Oakdale West Estate, Stage 3 (SSD-9794683)

Response to Submission

April 2021

Proposed Industrial Facility -Proposed Building 2A

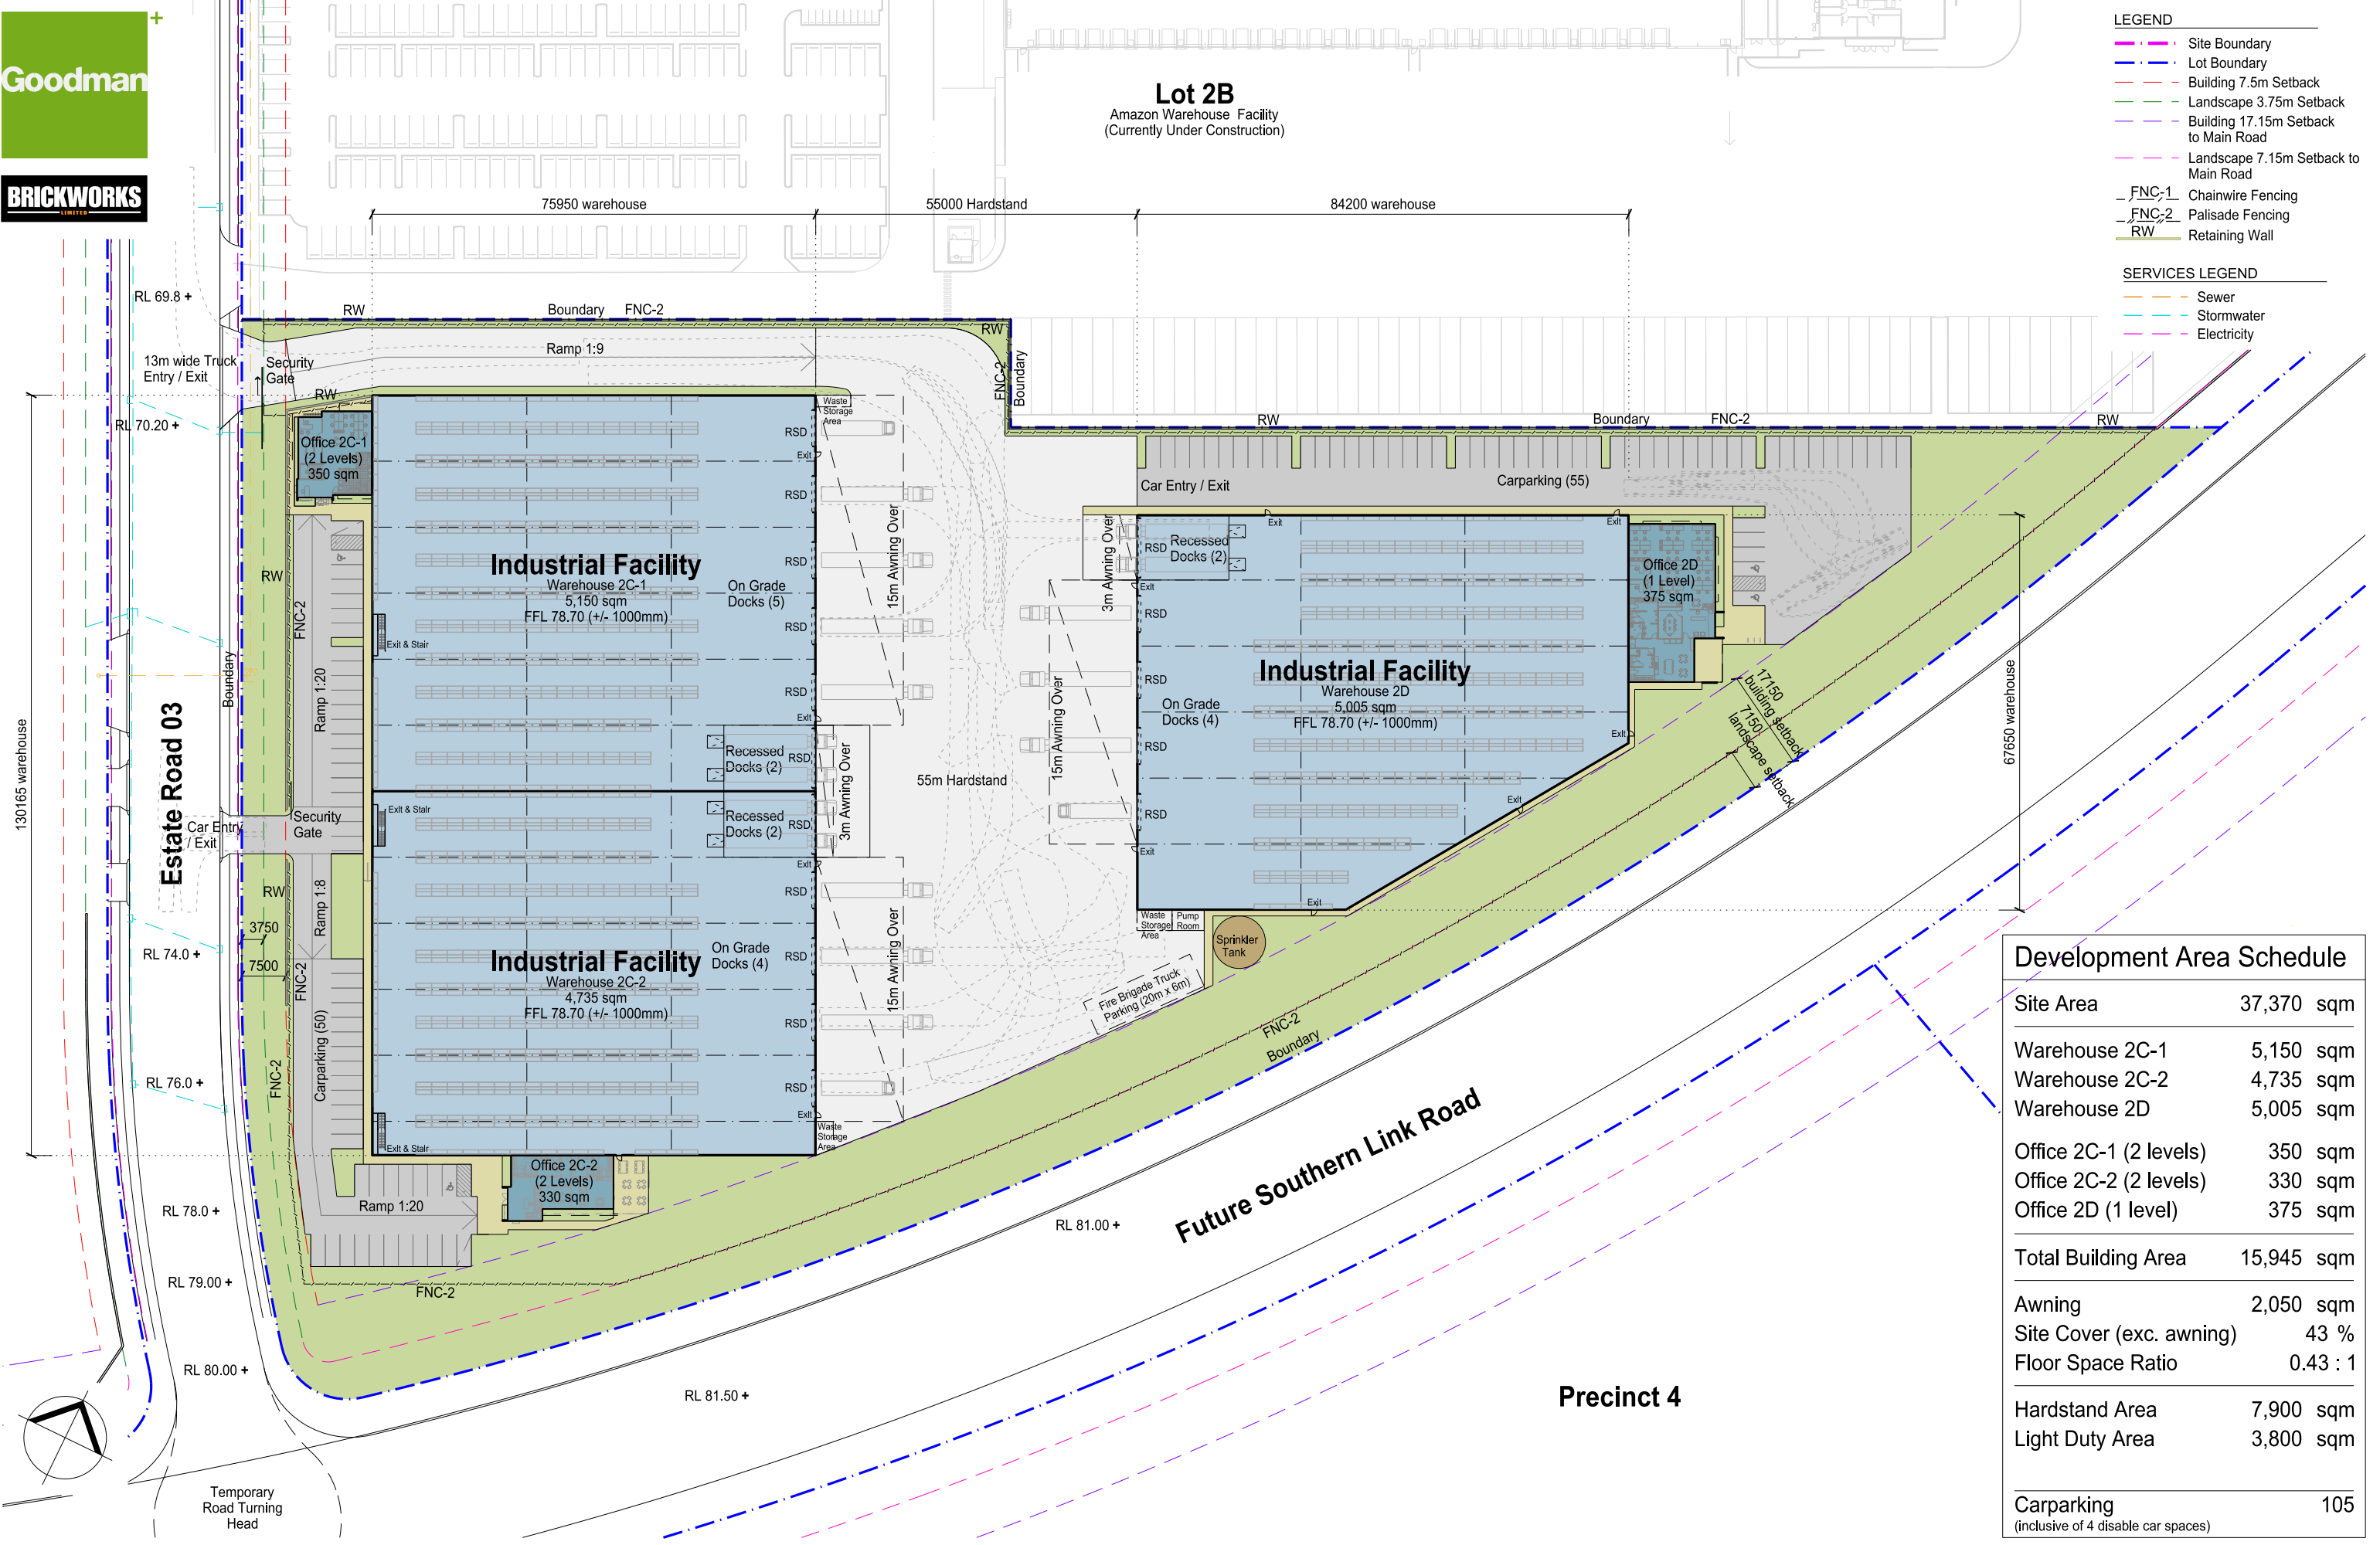
<ul style="list-style-type: none"> • Warehouse Lot 2A: Overall the building arrangement, car parking setbacks and building form is generally supported. Of particular note are the setbacks to car parking areas forward of the building line which respect that of preceding stages and provide a setback width which is critical in the achievement of the DCP objectives, irrespective of the 	<ul style="list-style-type: none"> • Noted
---	---

Swept Path Analysis

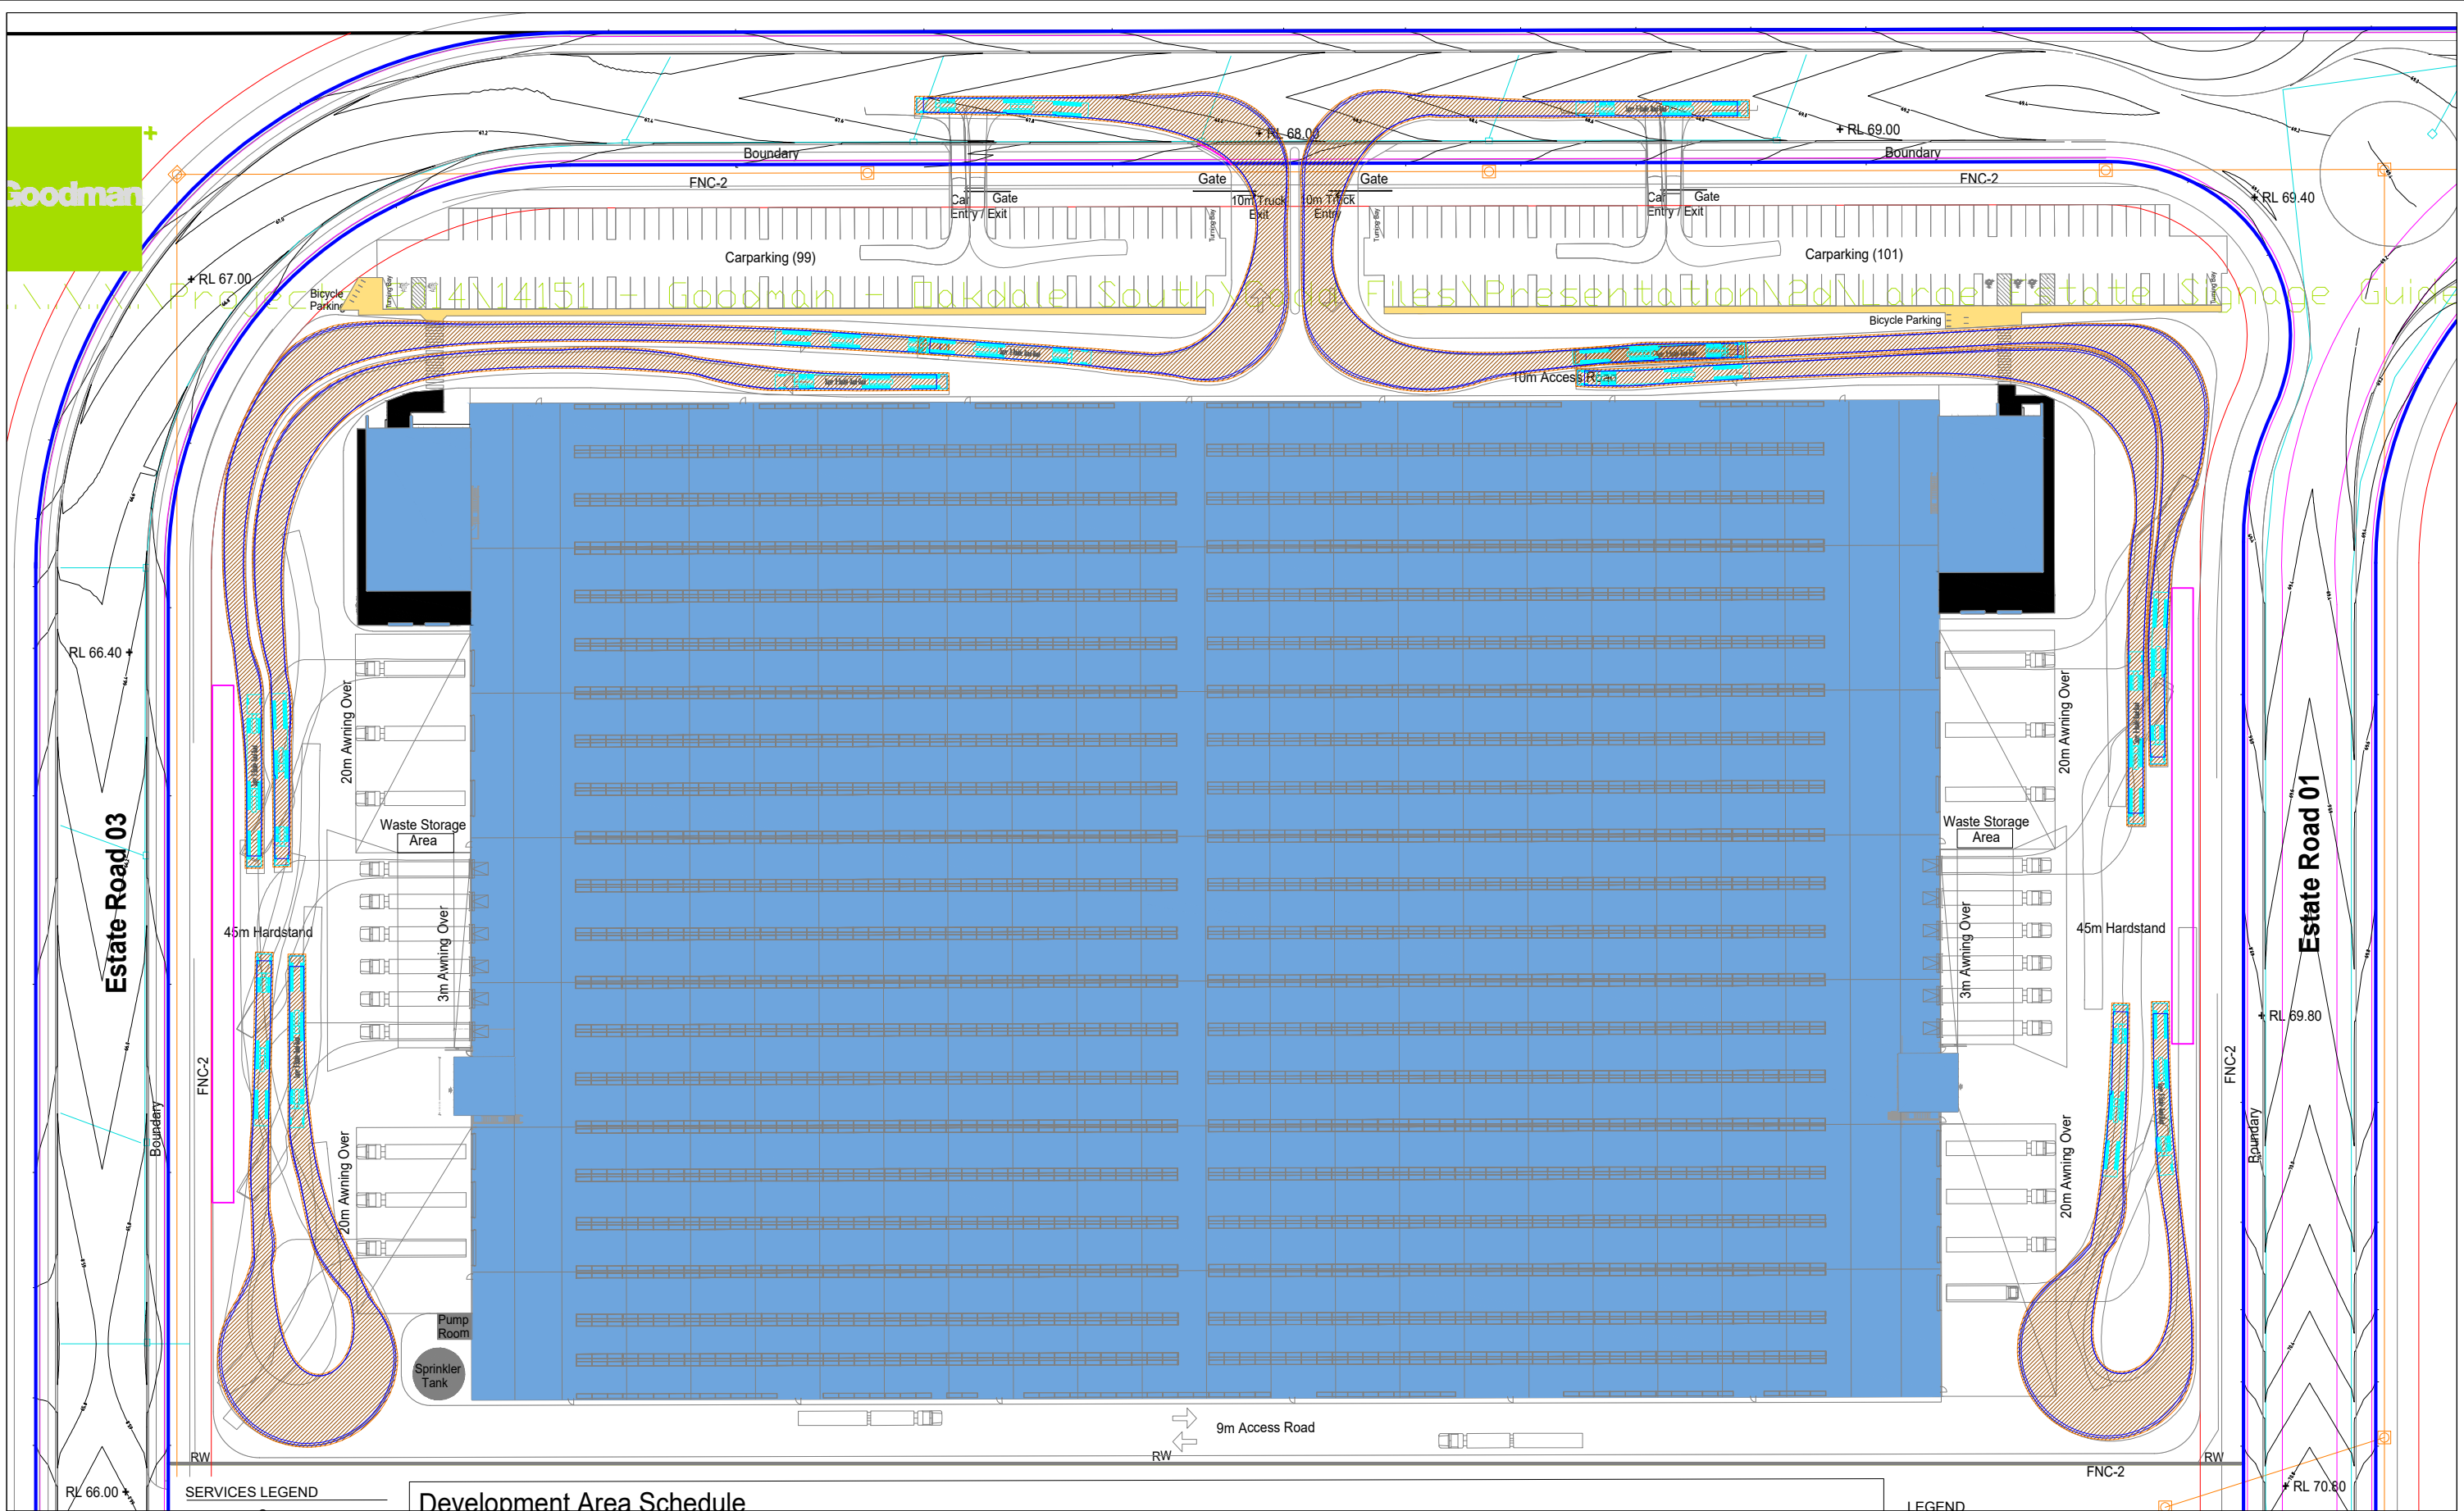
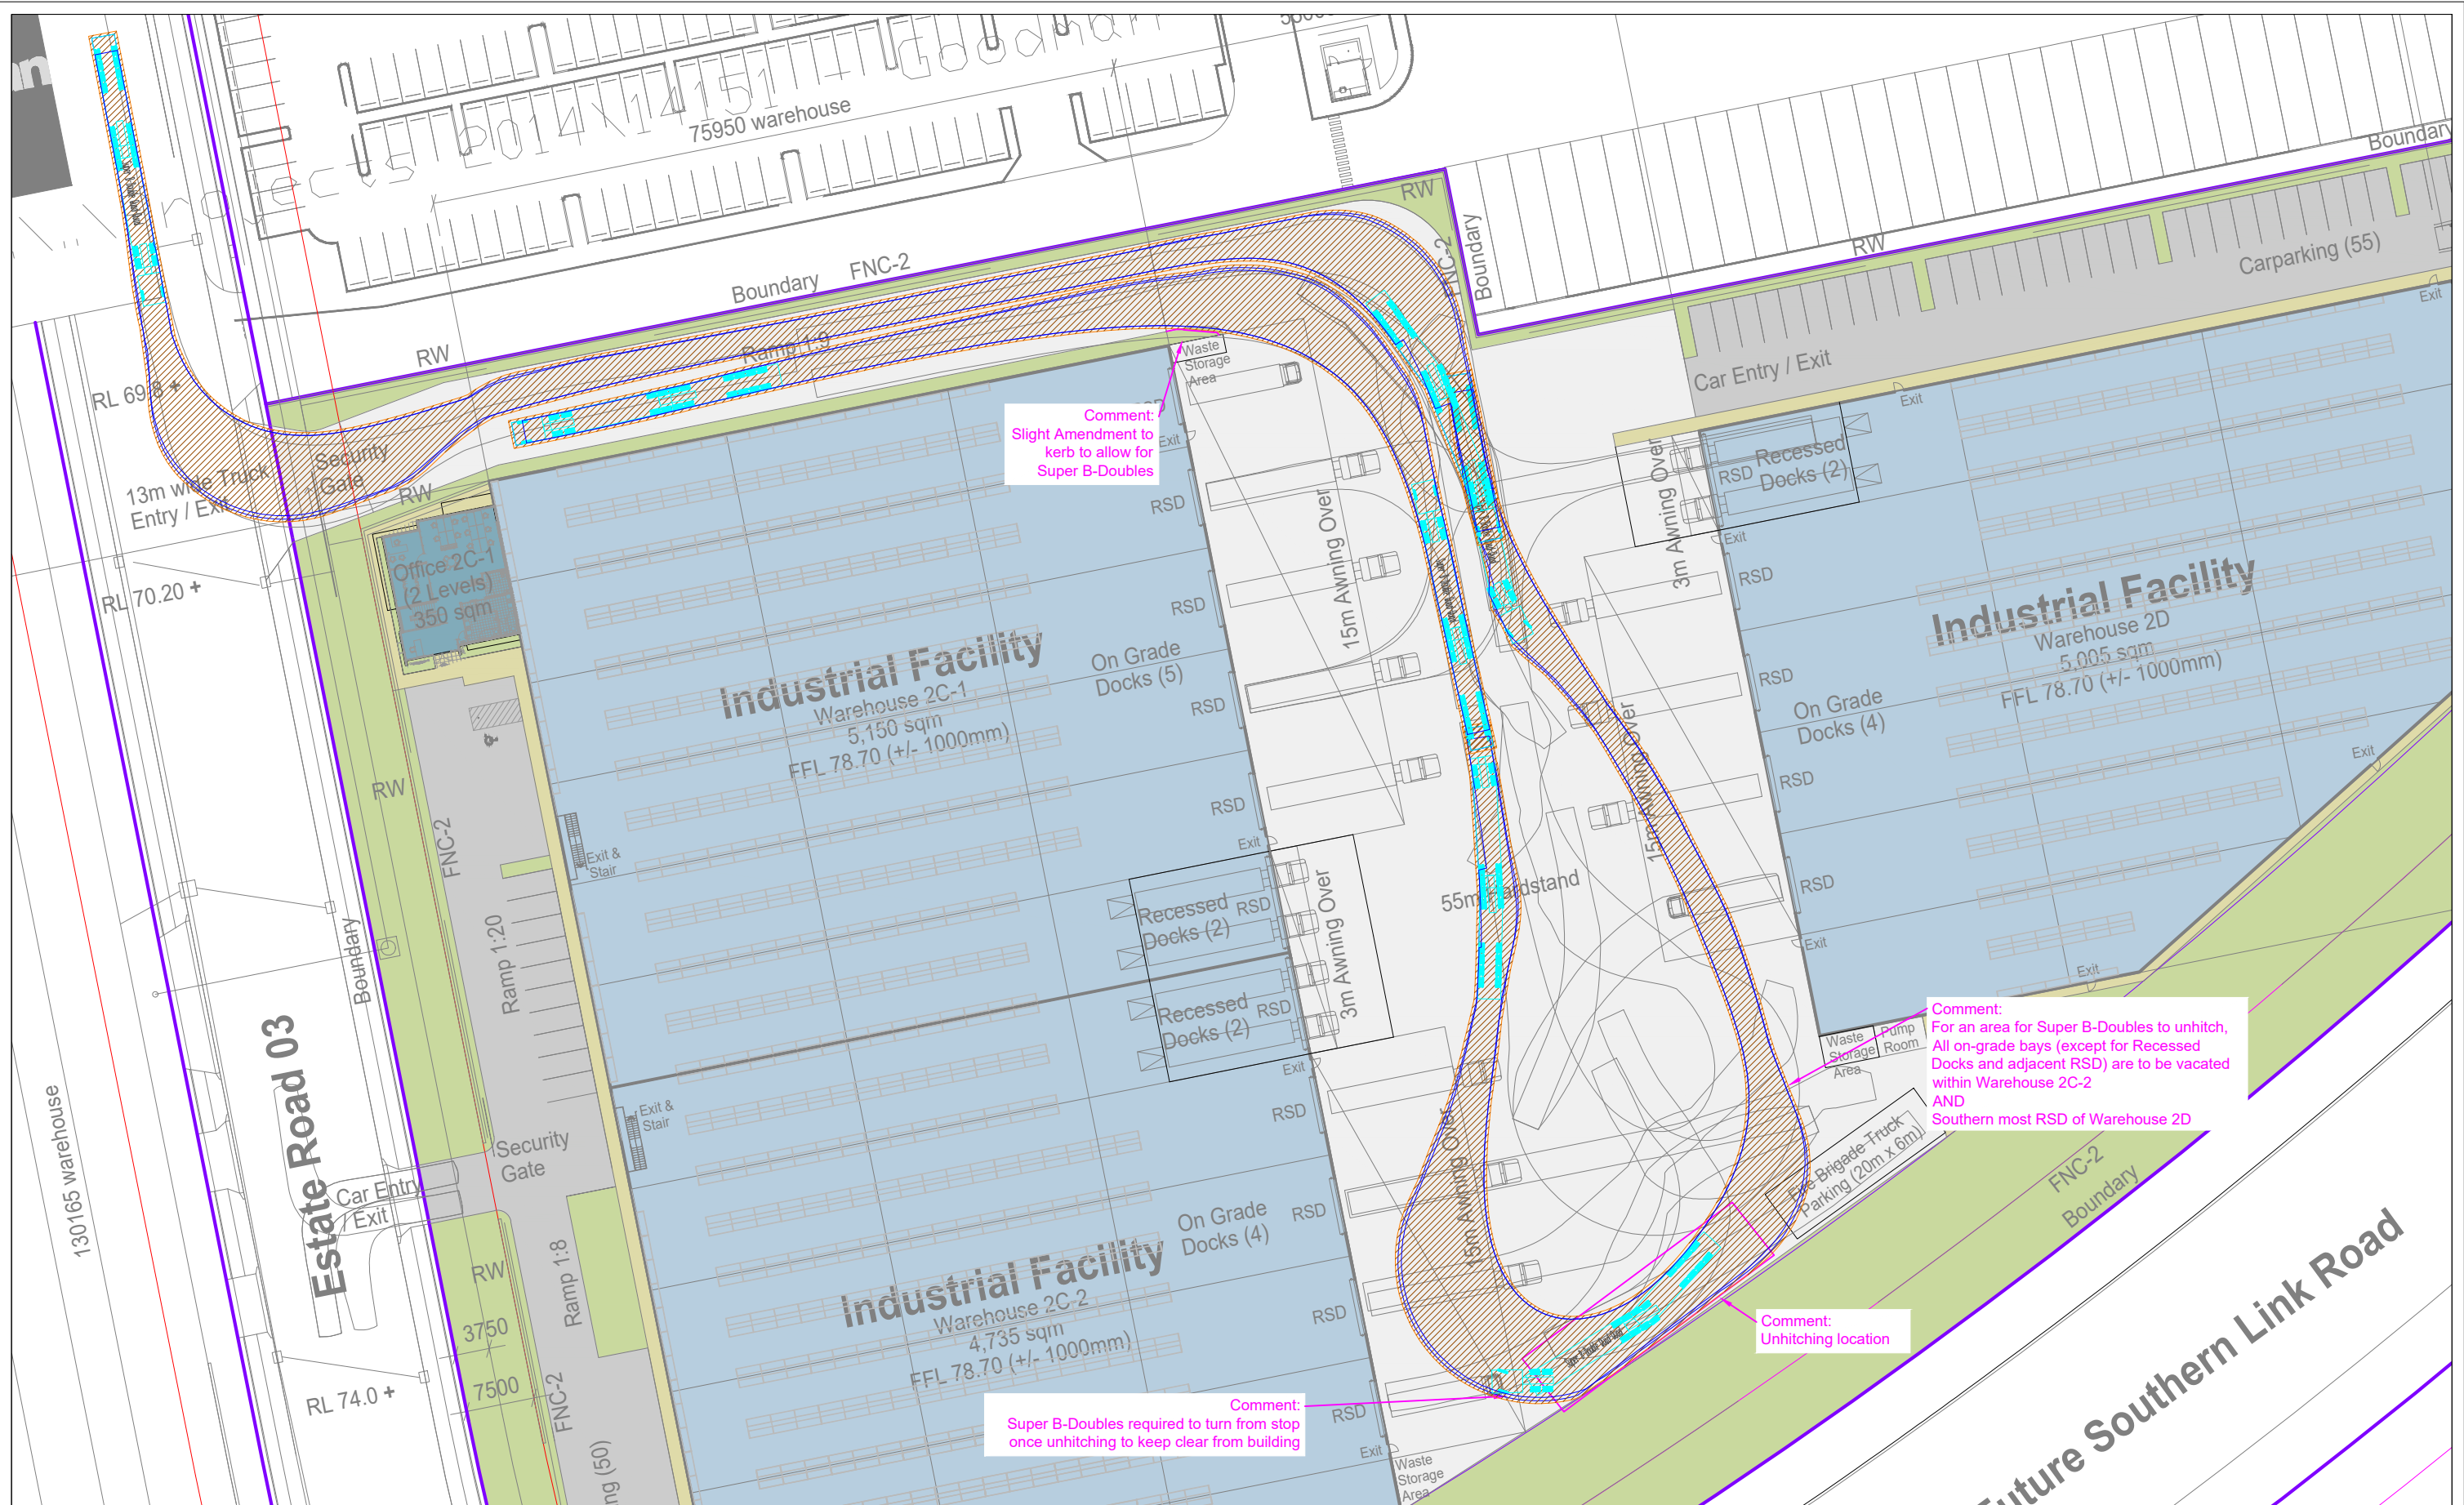
<ul style="list-style-type: none"> • In addition to the above point it I noted that the design of the internal road network within Building 2A does not allow for continuous 2 way flow. • The design should be updated to allow for the continual 2 way flow along the main access road, in particular on the corners where there is restricted sight distance to the satisfaction of Council. 	<ul style="list-style-type: none"> • Site Plan for Building 2A (Appendix C) has been updated to allow for continuous 2-way flow of super B-doubles. Relevant swept path analysis is included in Appendix B.
